**Southern
Water**

Your ref
BR/180/19/PL

Proposal: Erection of demountable/removable commercial unit at front facing London Road with residential unit at rear.

Site: BR/180/19/PL: - 37, London Road, Bognor Regis, PO21 1PQ.

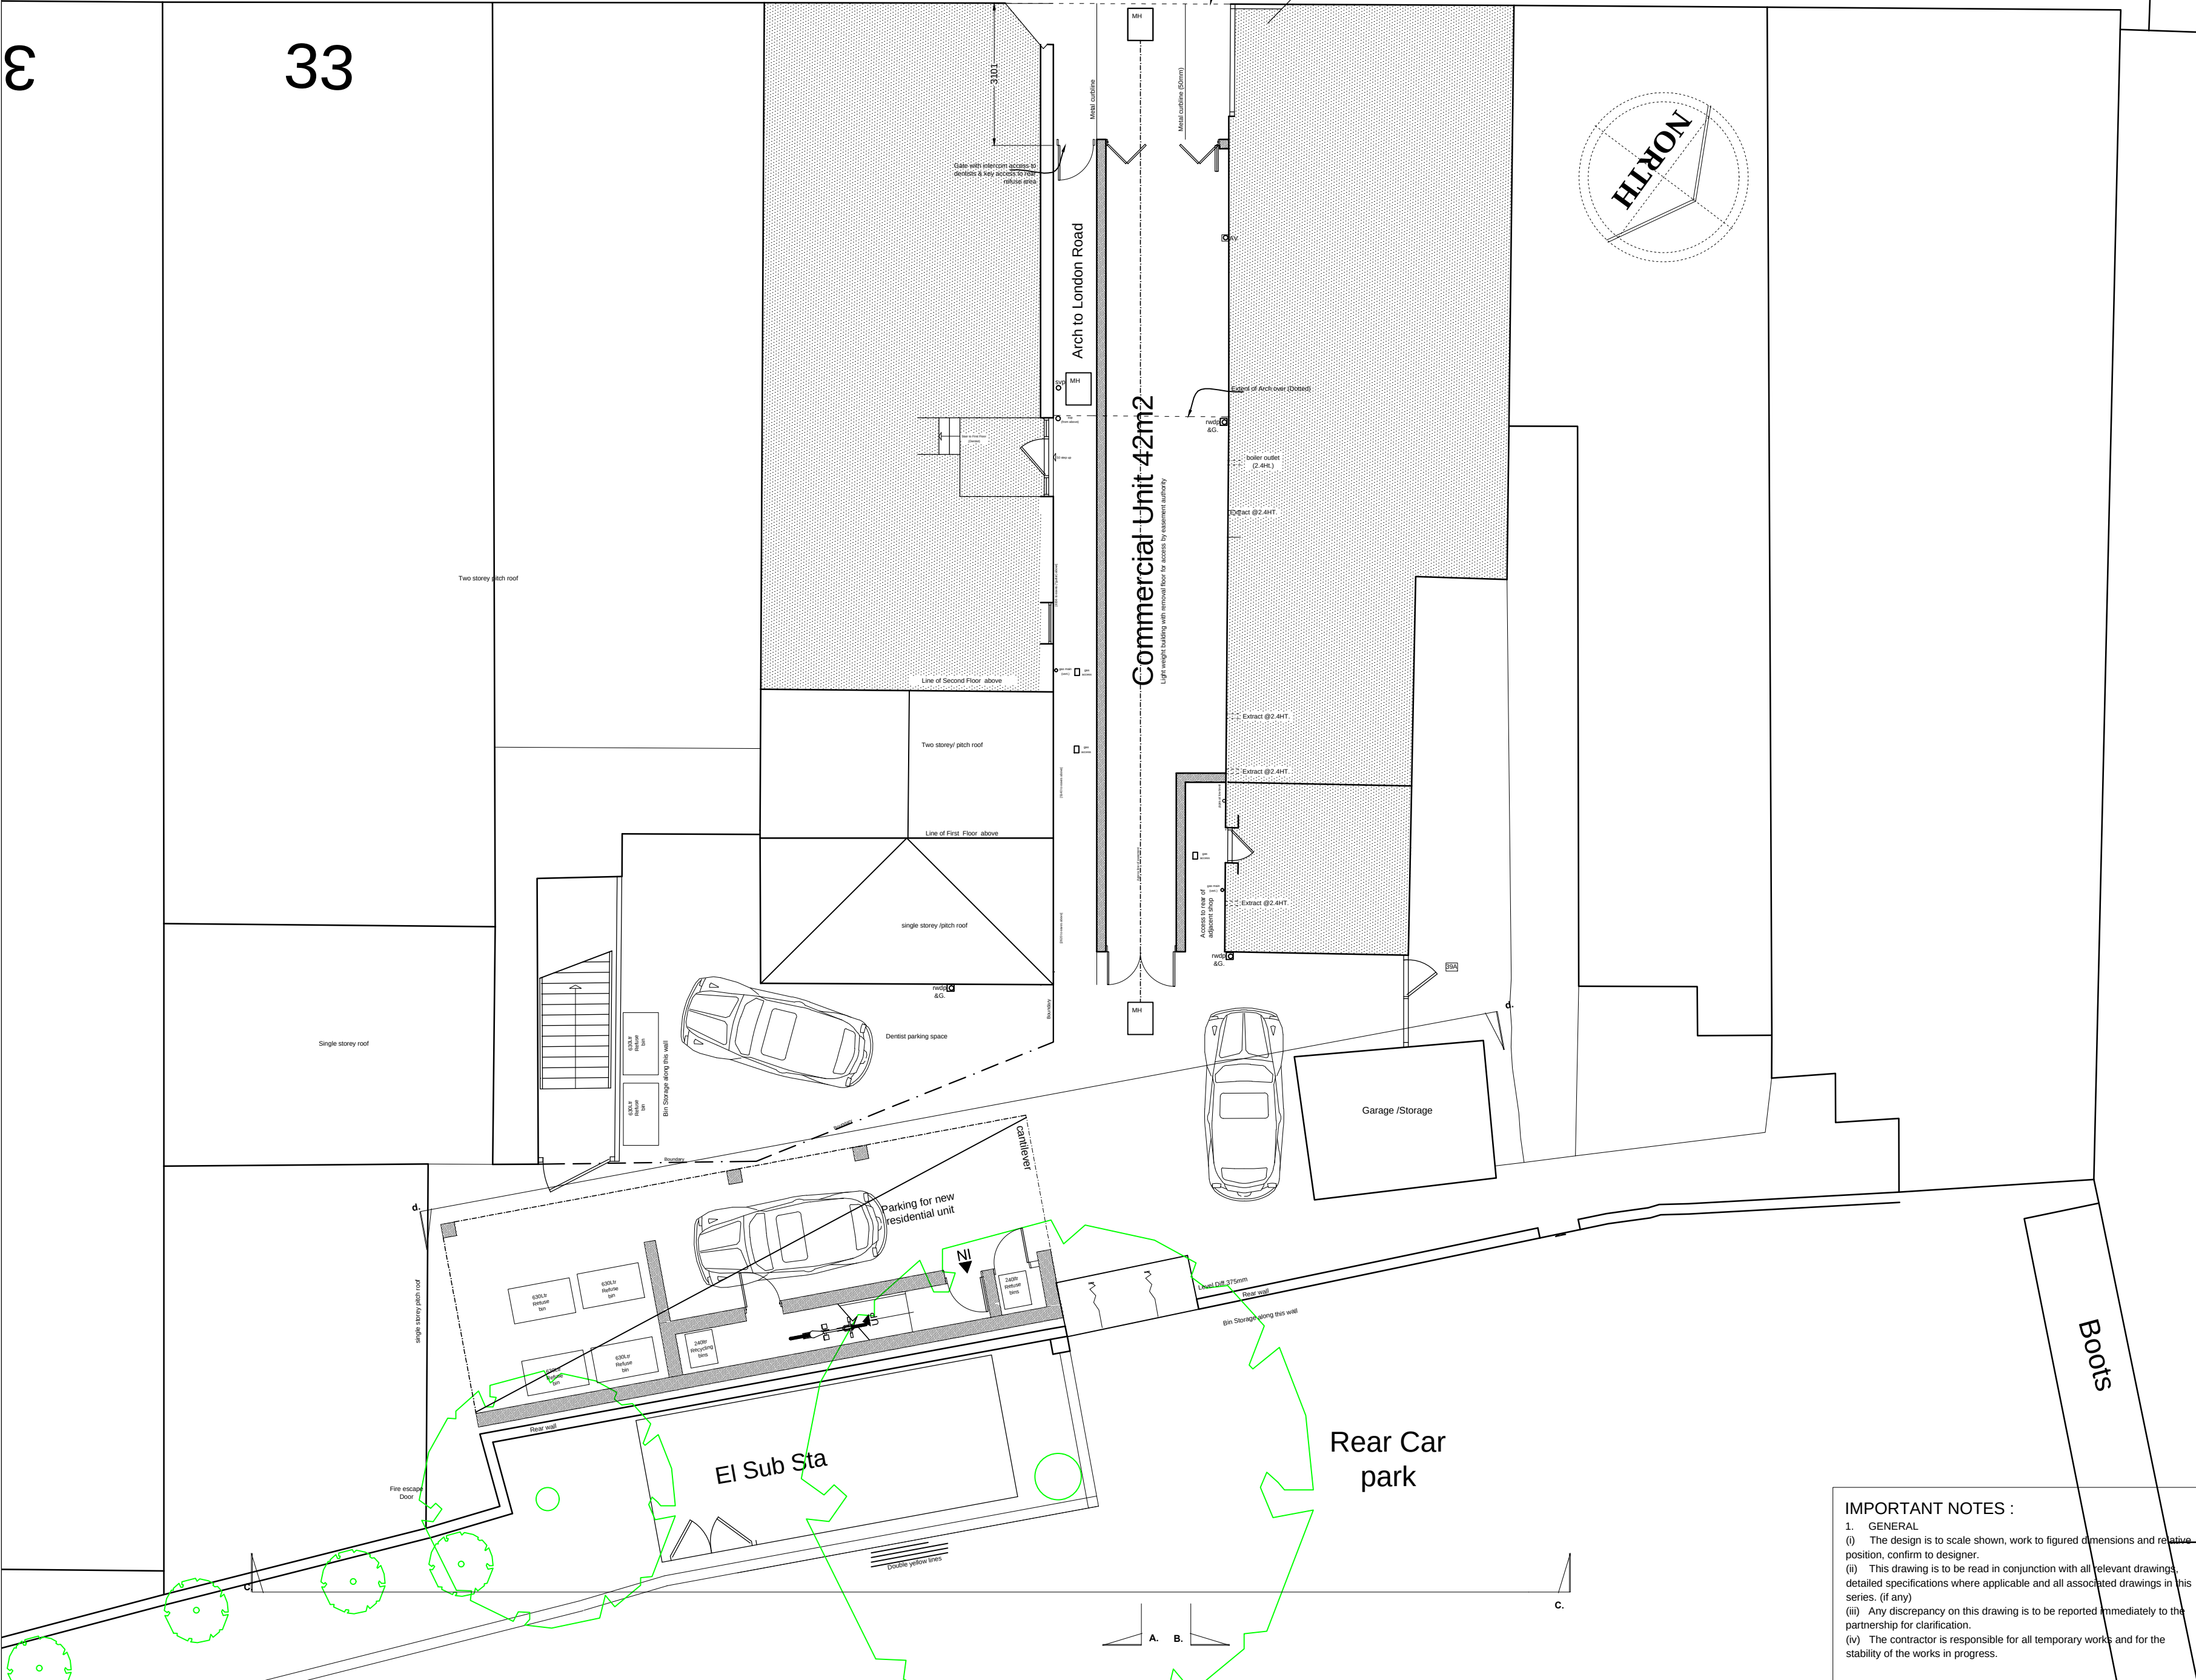
Please find attached a plan of the sewer records showing the approximate position of a public foul sewers within the site.

It might be possible to divert the public sewer, so long as this would result in no unacceptable loss of hydraulic capacity, and the work was carried out at the developer's expense to the satisfaction of Southern Water under the relevant statutory provisions.

1. The 100 mm diameter sewer requires a clearance of 3 metres either side of the sewer to protect it from construction works and allow for future access for maintenance.
2. No development or new tree planting should be located within 3 metres either side of the external edge of the public sewer.
3. No new soakaways should be located within 5m of a public sewer.
4. All other existing infrastructure should be protected during the course of construction works.

Alternatively, the applicant may wish to amend the site layout, or combine a diversion with amendment of the site layout. If the applicant would prefer to advance these options, items (1) – (4) above also apply.

In order to protect the foul sewer, Southern Water requests that if consent is granted, a condition is attached to the planning permission; for example, the developer must agree with Southern Water,

prior to commencement of the development, the measures to be undertaken to divert the public sewer.
